Briefing Note

Our ref 64194/06/MS/OW
Date 1 July 2025
To Planning Inspectorate
From Oxford Aviation Services Limited

Subject **Deadline D2 – Response to ExQ1**

- 1.1 This response has been prepared on behalf of Oxford Aviation Services Limited (“OASL”), the operators of London Oxford Airport (“the Airport”), in response to the publication of written questions (ExQ1) by the Examining Authority concerning the application by Photovolt Development Partners (“PVDP”) for an Order Granting Development Consent for the Botley West Solar Farm project.

Relocation of the Proposed Substation and Western Panel Removal

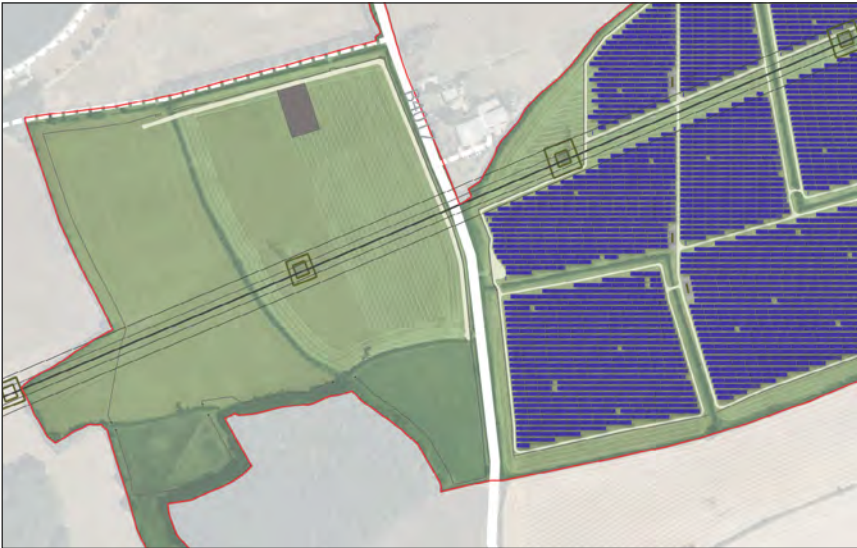
- 2.5 A substation cannot be located where it breaches the Obstacle Limitation Surfaces (OLS). However, outside of this requirement, there is no need for one to have safety lighting. Currently, one of the substations would penetrate the OLS, within the transitional slope – this is not acceptable. The applicant and Airport have met to discuss this matter, and the applicant has undertaken to make the necessary changes to remove the breach, relocating the substation. Assuming this amendment is formalised through a change order, the Airport has no further comment to make on substations.
